From: Cian Cronin
Sent: 24 January 2014 08:41
To: Planning.Responses
Subject: FW: Y/87/13

From: Joe Russell-Wells
Sent: 23 January 2014 15:12
To: Cian Cronin
Cc: 'Owen Pike'
Subject: Y/87/13

The proposed development has the potential of having a visual impact within the proximity of the development. The proposal in within 2 landscape character areas the Arun Landscape Study 2006 both of which identify these areas as having substantial landscape sensitivity and a low/medium landscape capacity. The study was completed to inform where major development could occur without an unacceptable impact on landscape impact.

1. Indicative hedge and tree belt planting details (for northwest, northeast and south west boundaries)

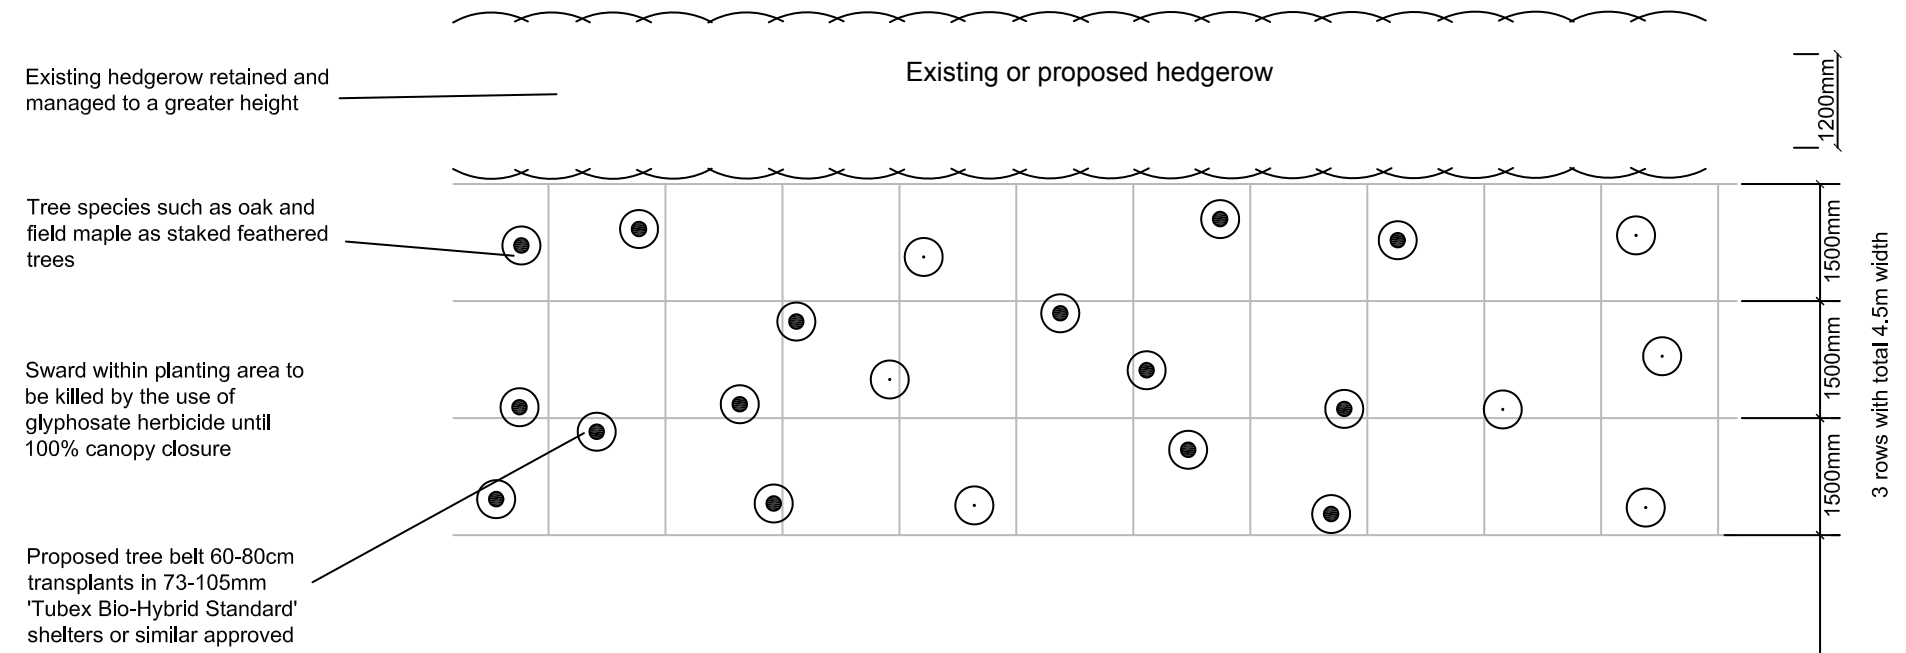
The planting proposals identify the planting of a hedge line at a width of 1.2 m on the SE boundary and Indicative hedge and tree line at approx. 5 m width on the NW, NE and SW boundaries. There is no detail of species other than suggested oak and Field Maple both of which would be acceptable as native species. In order to ensure that satisfactory screening is to be provided further information as to the species to be planted should be set out at this stage. Species must be comprised of natives matching those of the surrounding landscape. Consideration to all year round screening must be included – it's likely this will include ivy which will naturally introduce itself in time – however suggestion of how this screening mitigation will be met all year round together with a timeline of how long after planting the screening will for fill the screening requirement must be submitted. Other measures to ensure full establishment of the planting must also be provided and included in a management plan for these planting areas.

The inclusion of species suitable to near coast conditions has been stated – as stated above emphasis must be made on species already growing in this area as a guide to species to be used. Species such as *Hippophae rhamnoides* must be avoided.
